Subject: 2021/93674 Partial redevelopment of Greenhead college including demolition, erection of 2 and 4 storey buildings, reconfiguration of parking and access arrangements and associated external works
Date: 19 October 2021 16:29:29

Dwg. No.	NE8659- OOB- ZZ- 00- DR- L- 0001	Scale	1 : 500 @ A2
Revision	P25	Date	February 2021

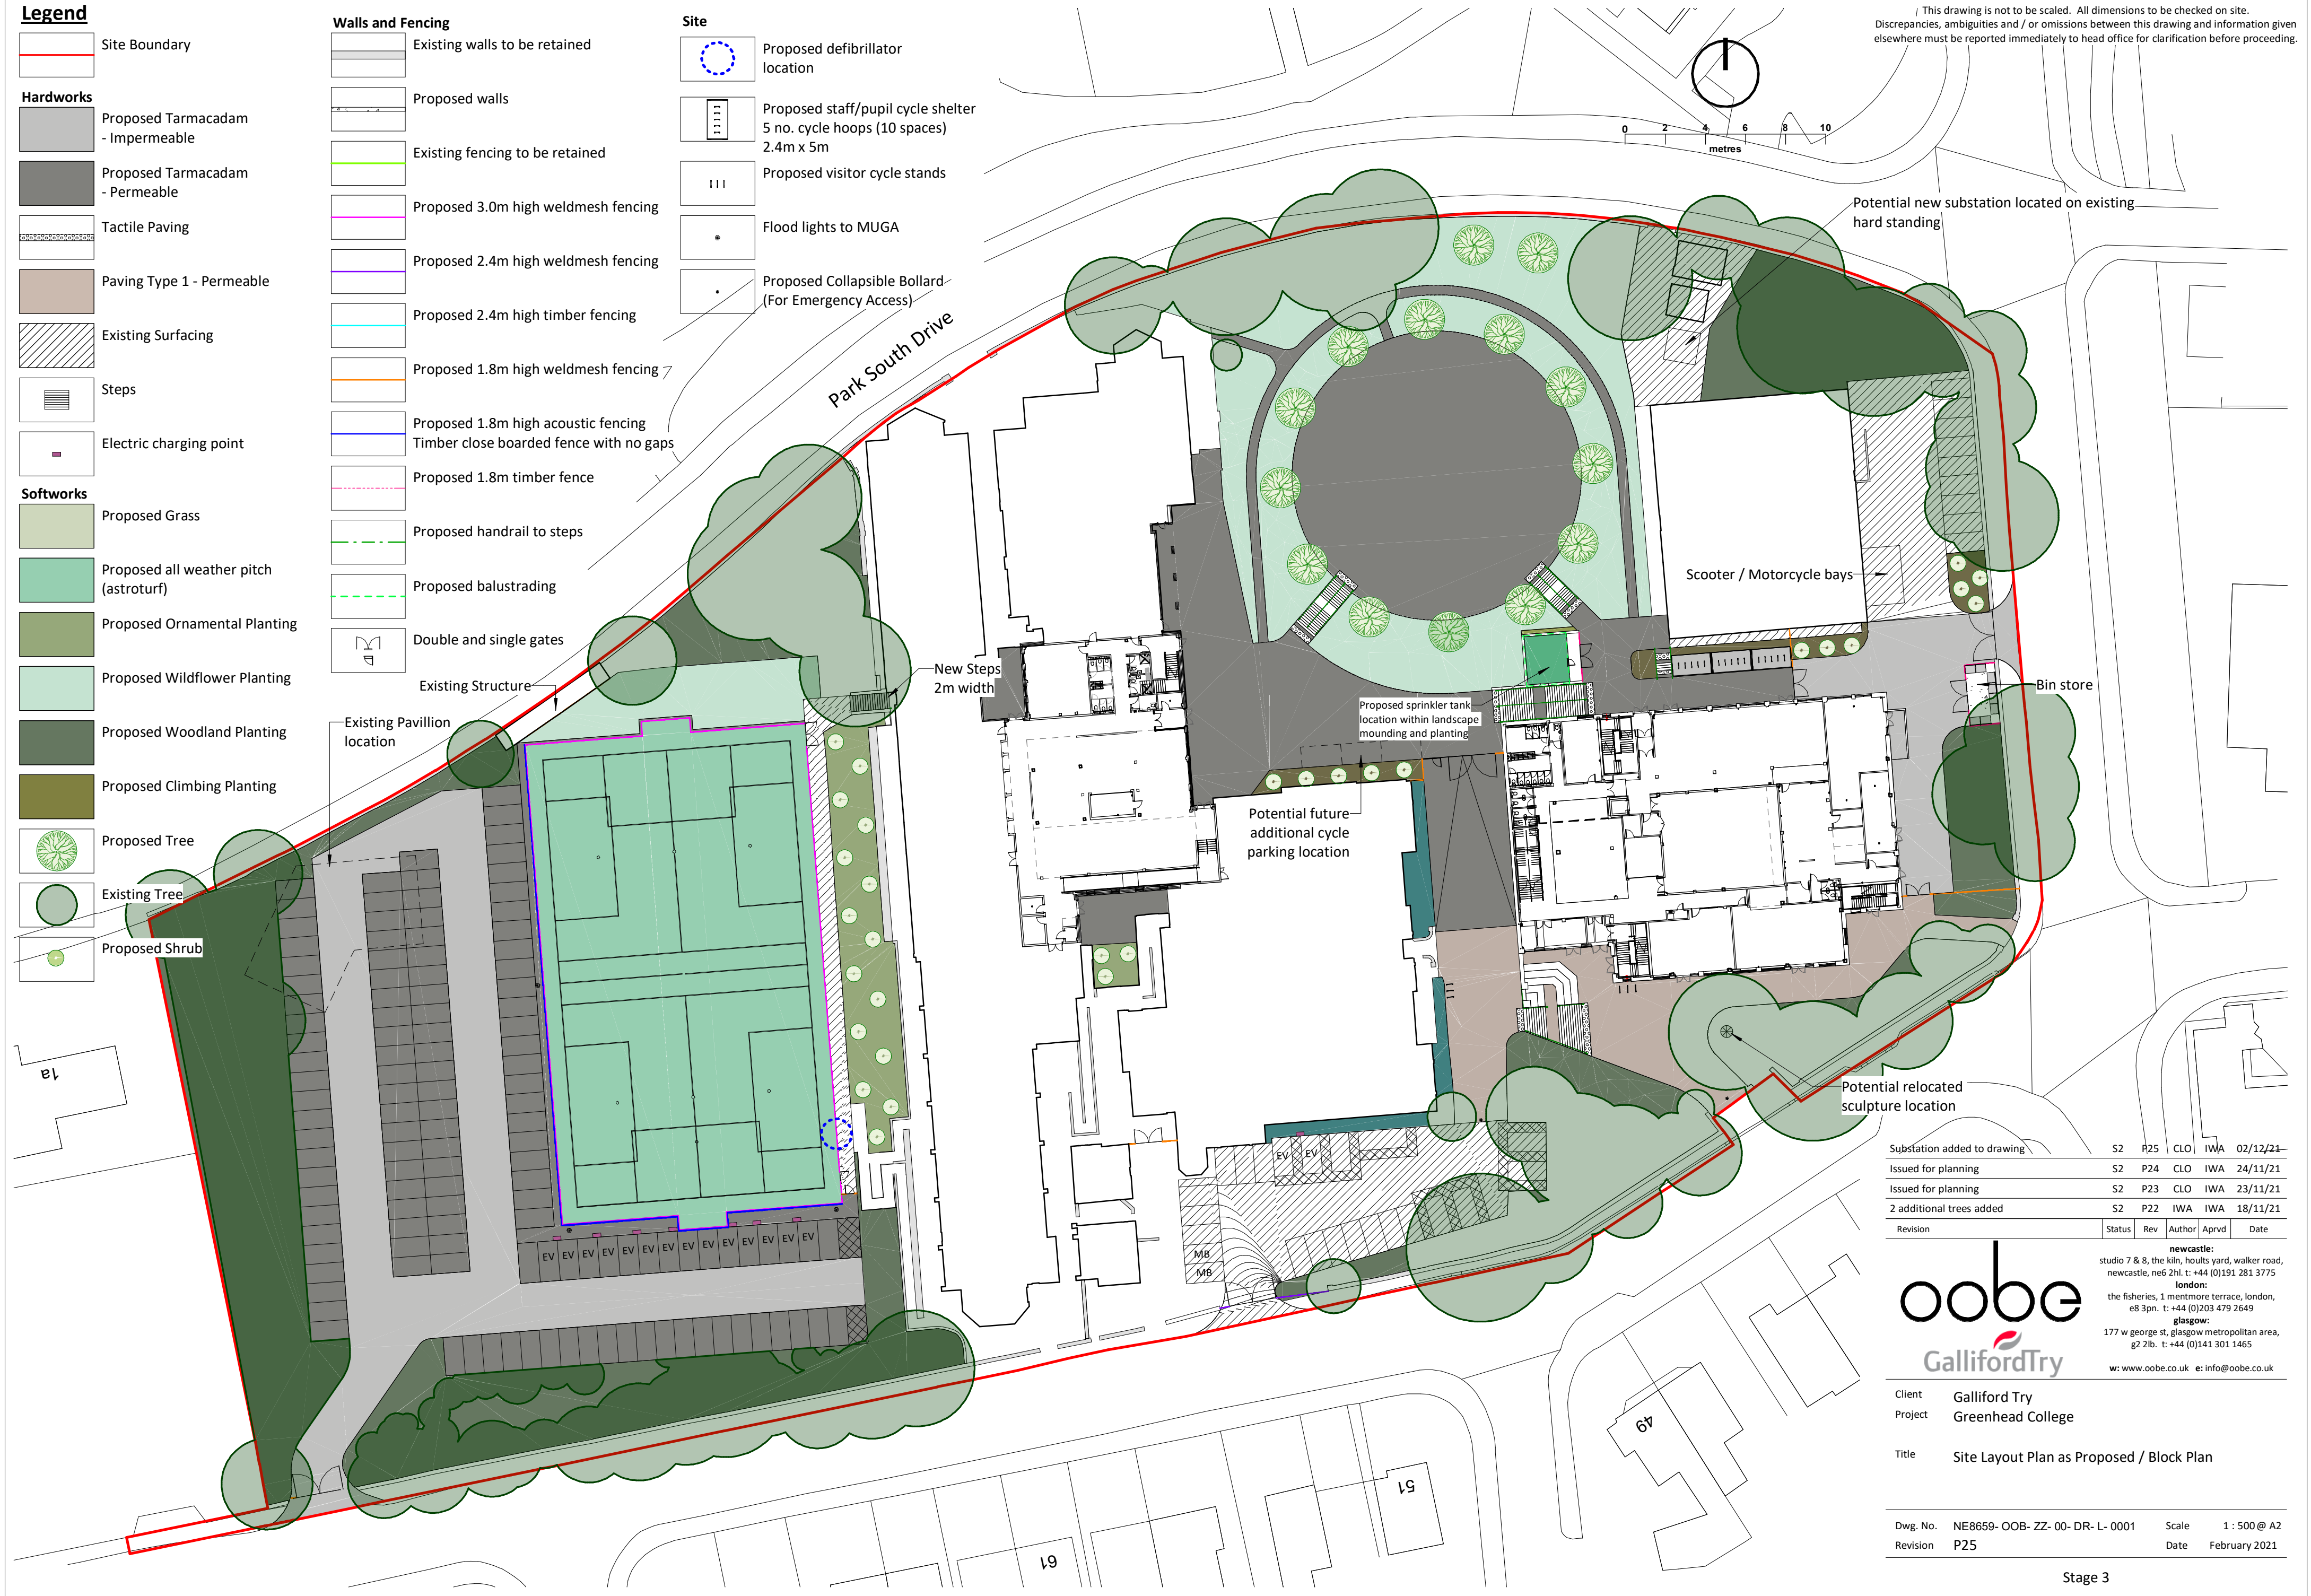
The proposed plans show a replacement floodlit AGP of reduced dimensions, re-orientated and repositioned. Land to the south and west is taken up with car parking with the changing rooms reprovided within the proposed infill buildings. The two MUGA courts are not reprovided.

The playing field area reduces by over 50% between the existing and proposed layouts, and as a result the proposal cannot meet [the quantitative test of] playing field policy exception 4. Such a scenario would normally result in a statutory objection from Sport England, but there instances where a proposal can demonstrate an overall gain for sport which outweighs playing field policy.

Whilst the proposal is not considered to meet playing field policy – exception 4, Sport England has **no objection** to the proposal as the proposed community use offer by the applicant is considered to be significant benefit to sport. Sport England's 'no objection' response is subject to the imposition of the following condition:

Use of the development shall not commence until a community use agreement prepared in consultation with Sport England has been submitted to and approved in writing by the Local Planning Authority, and a copy of the completed approved agreement has been provided to the Local Planning Authority. The agreement shall apply to proposed artificial grass pitch and off-site playing pitches and include details of pricing policy, hours of use, access by non-college users, management responsibilities and a mechanism for review. The development shall not be used otherwise than in strict compliance with the approved agreement."
